DECISION DELEGATED TO HEAD OF PLANNING

Application No: H02-0572-26 **Applicant:** Lincolnshire Co-Operative Limited

Proposal: Freestanding digital signage unit inside storefront - Retrospective

Location: Lincolnshire Co-Op Ltd 8-10 West Street Crowland

Positioning Plan:

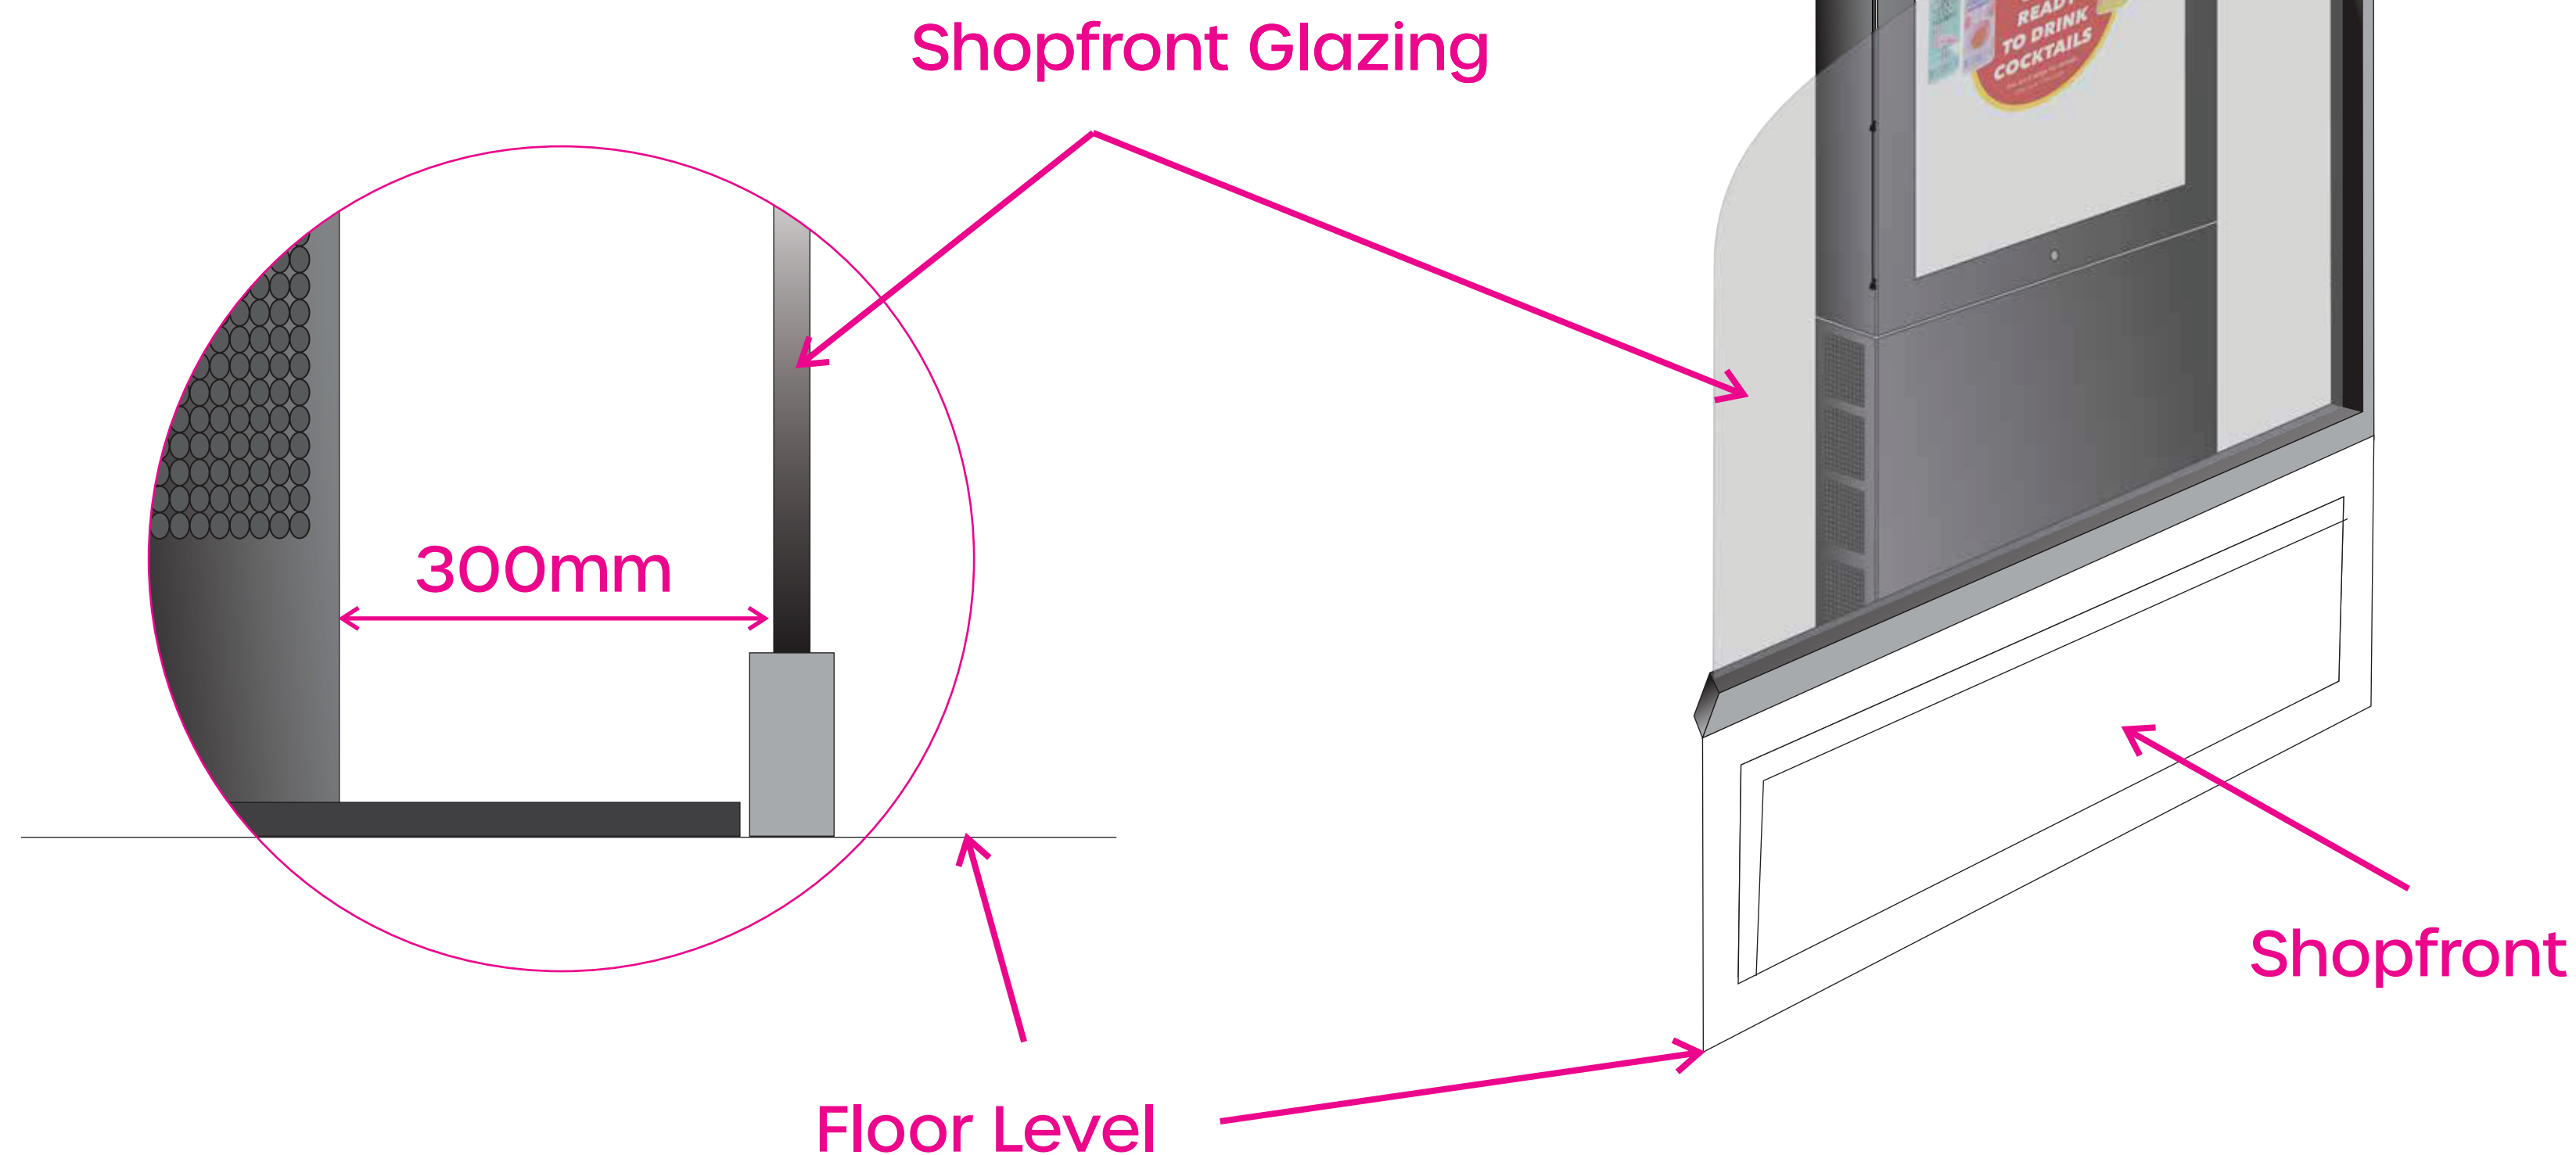
A less harmful alternative would be to position the advertisement unit further within the store, beyond the shopfront glazing and outside public views. In such a location, the display would have a neutral impact on the character and appearance of the Conservation Area while still enabling the applicant to utilise it for in-store advertising purposes.

The unit is proposed to be positioned on a baseplate and the screen is approximately 30cm from the inside surface of the shopfront glass.

The conservation officer considers that the advertisement would introduce a modern and visually intrusive feature into the Conservation Area, thereby failing to preserve its character and appearance. The conservation officer has suggested moving the advertisement "further within the store, beyond the shopfront glazing and outside public views". Whilst this suggestion has been considered, it is considered that the proposed revised location would undermine the purpose of the sign which is to advertise the business.
